<b>File reference</b>	TR010030
<b>Status</b>	<b>Final</b>
<b>Author</b>	The Planning Inspectorate
<b>Date</b>	January 2019
<b>Meeting with</b>	Highways England
<b>Venue</b>	Bristol
<b>Meeting objectives</b>	Draft documents and submission
<b>Circulation</b>	All attendees

## **M25 Junction 10/A3 Wisley Interchange Project**

### **PINS comments on draft Application documents**

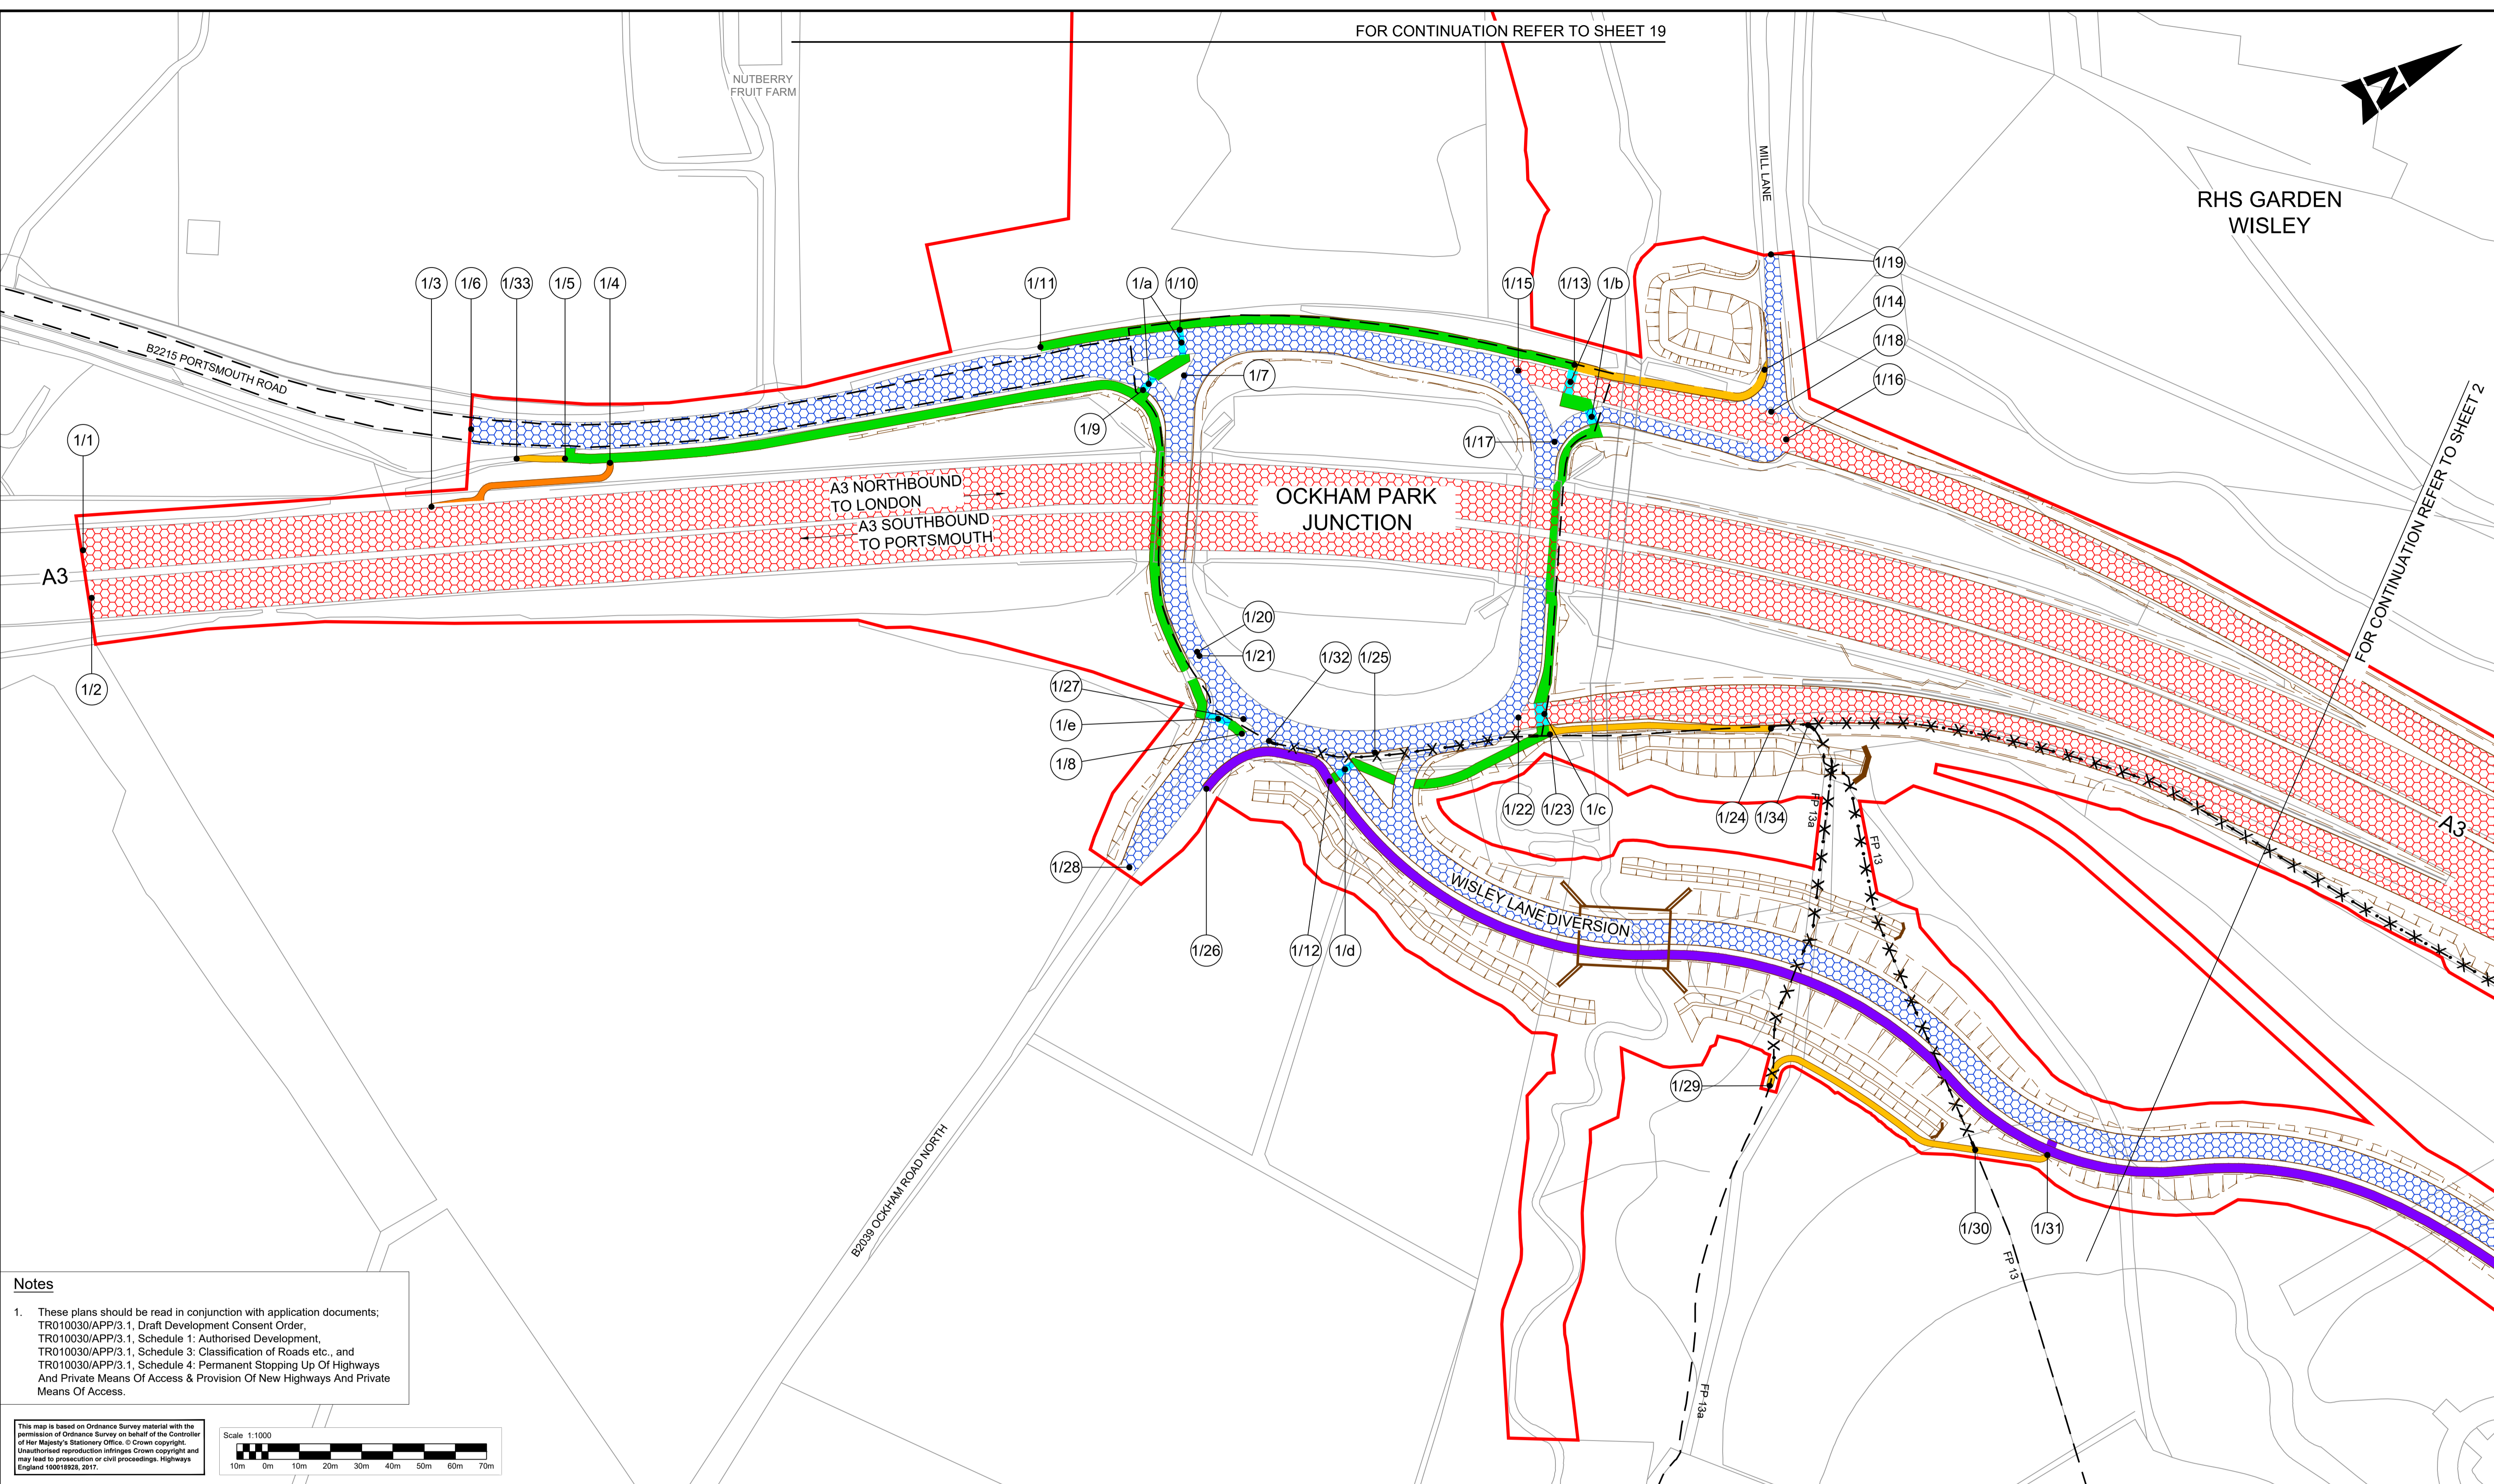
<b>Streets, Rights of Way and Access Plans - TR010030/APP/2.4</b>			
<b>No.</b>	<b>Doc Ref</b>	<b>HE comments on draft document</b>	<b>Comments</b>
<b>15.</b>	Streets, Rights of Way and Access Plans  Sheet 1 of 31		The Inspectorate advises you to compare the Streets, Rights of Way and Access Plans and Works Plans to ensure that all works appear correctly on the plans or perhaps to explain your approach within the documents. We draw your attention particularly to Street work 1/3 and Work No. 31. See 12 above.
